**BEFORE the HEARING EXAMINER for the
CITY of MERCER ISLAND**

FILE NUMBERS: CAO15-001 & VAR18-002

TYPE OF CASE: Consolidated: 1) Critical Areas Reasonable Use Exception to construct a single-family residence and associated improvements within a regulated wetland and required wetland and stream buffers; and 2) Variance from the setback requirement from an access easement

EXAMINER DECISION: REMAND

TITLE AND TESC PLAN
5637 MERCER WAY
MI TREEHOUSE, LLC
11030 SE 30TH ST
BELLEVUE, WA 98004

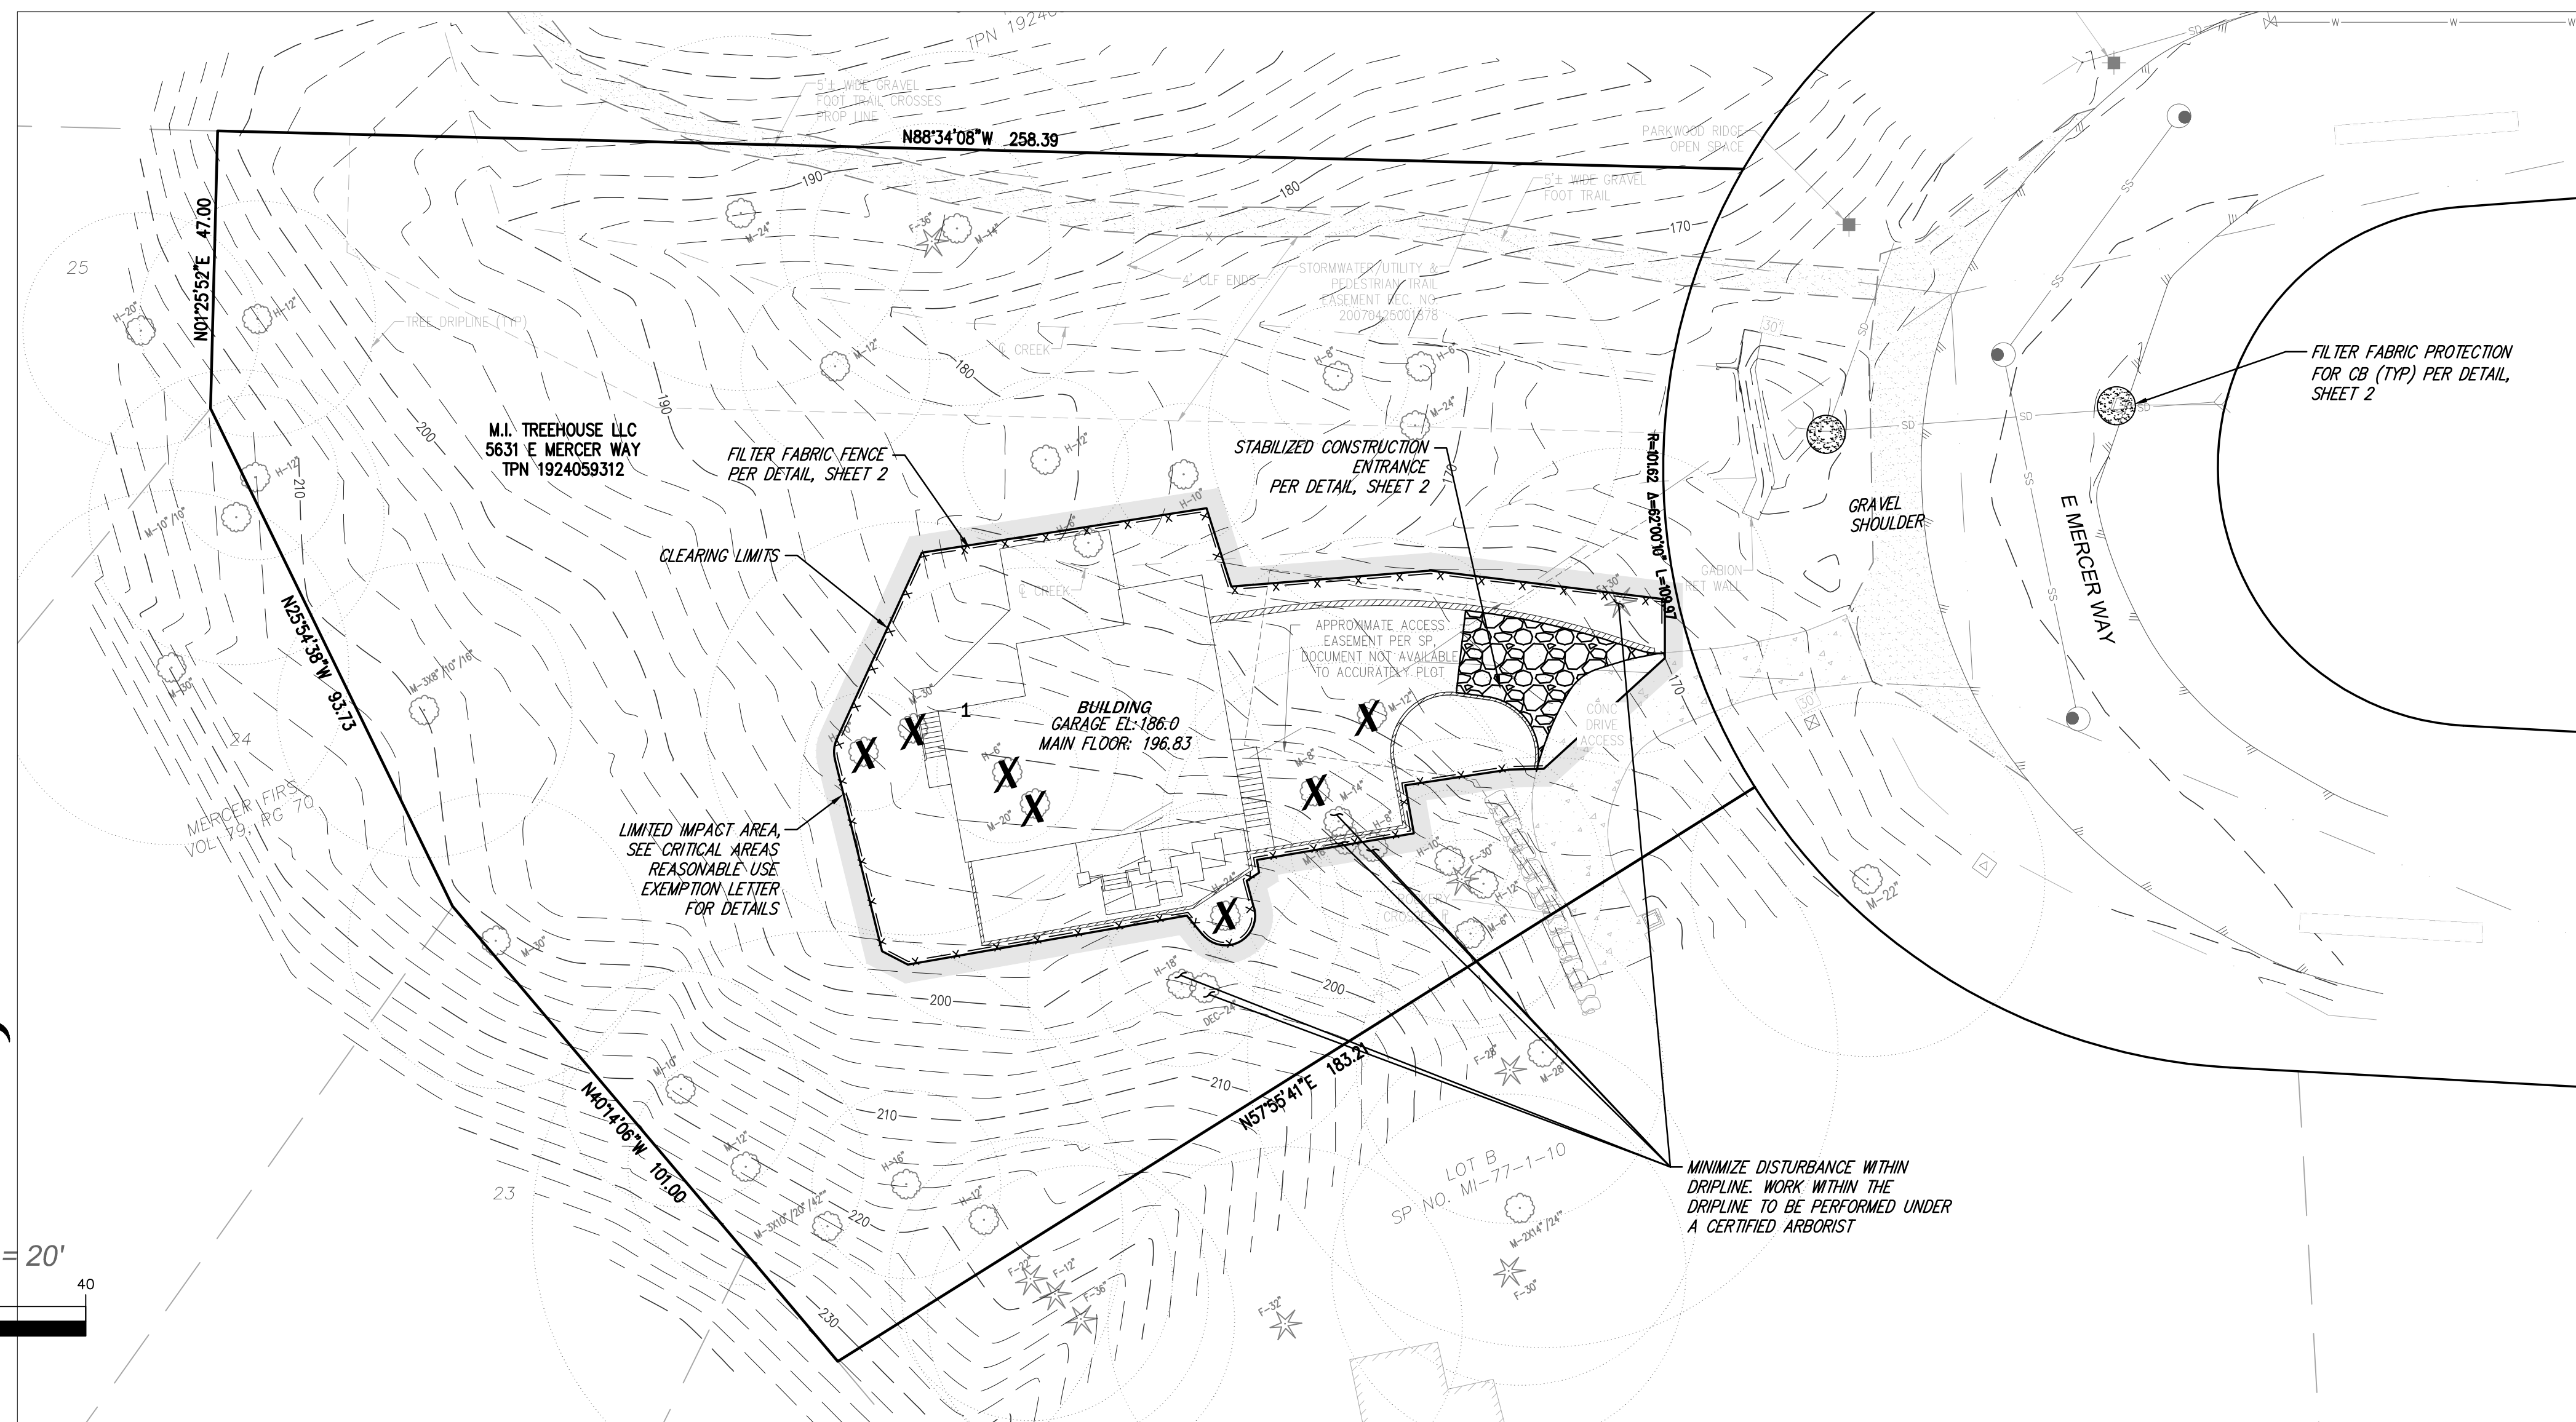
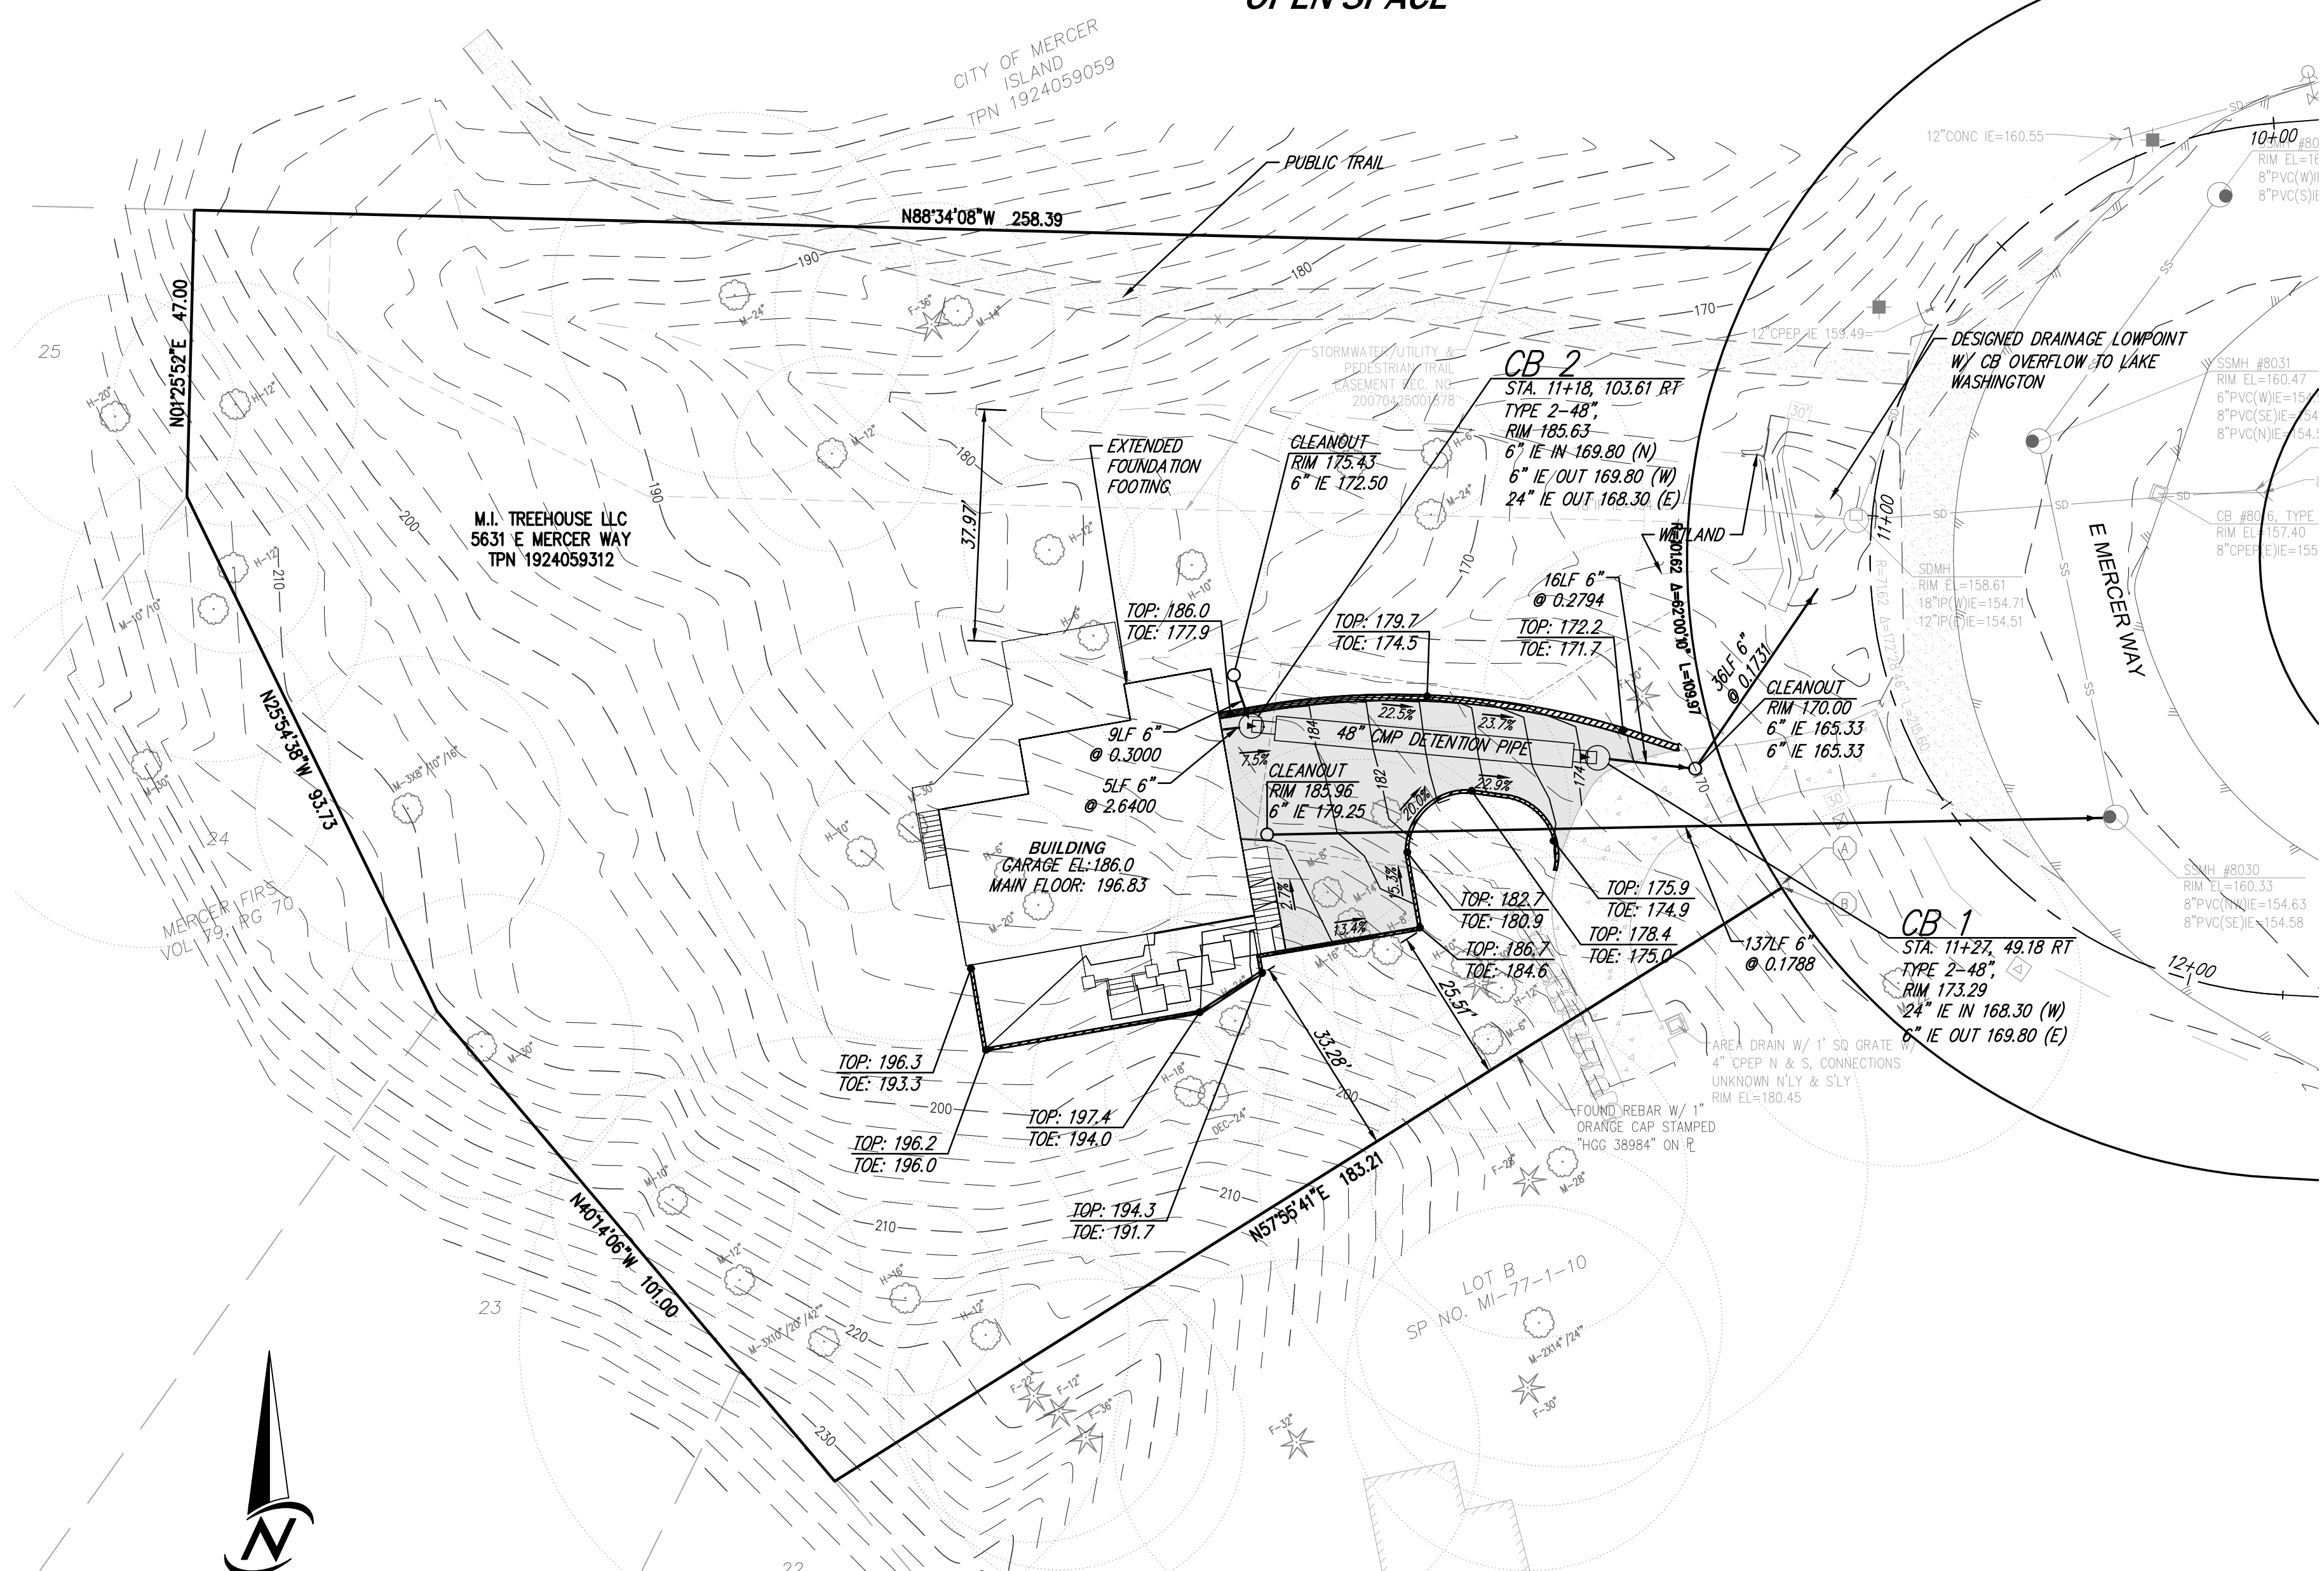
⁶ The west property line segment call-out lengths on the currently proposed site plan (Exhibit 38) match the call-out segment lengths on the original short plat that created Parcel 9312 (Exhibit 39). However, the line segments as drafted on Exhibit 38 do not match the call-out lengths: The north segment which should be 47 feet is drawn as 57 feet; the middle segment which should be 94 feet is drawn as 65 feet; and the south segment which should be 101 feet is drawn as 119 feet. The total length is about the same, but the segment lengths and resulting angles are inaccurate. Thus, it appears that Parcel 9312’s shape is inaccurately presented on Exhibit 38.

Neither the off-site northern or western steep slopes are depicted on the proposed site plan, Exhibit 38.

⁸ The inference from the contour lines on Exhibit 38 near the north property line that the parcel to the north exhibits gentle slopes is most likely quite mis-leading. Exhibit 23, Appendix A, PDF pp. 6 & 7 strongly suggests that the slope becomes significantly steeper immediately to the north.

15. Stream B is depicted in various locations and with various lengths on the maps and plans contained in the record. (Exhibits 12b, PDF pp. 3 & 20¹⁰; 12c, PDF p. 7; 38; 42d, PDF p. 5) On the latest project plan (Exhibit 38) Stream B defies geographical logic: It is depicted as flowing diagonally down the shallow side wall of a small, on-site draw. Streams simply do not do that in the real world.¹¹ Streams flow down the centerline of draws or ravines, not slaunchwise down their sides. If the topography on Exhibit 38 is accurate and if Stream B were properly mapped, it would originate at or flow beneath the northeast corner of the proposed residence, depending on its length. By drawing Stream B on the side of the slope, it misses the house by about seven feet. (Exhibit 38)
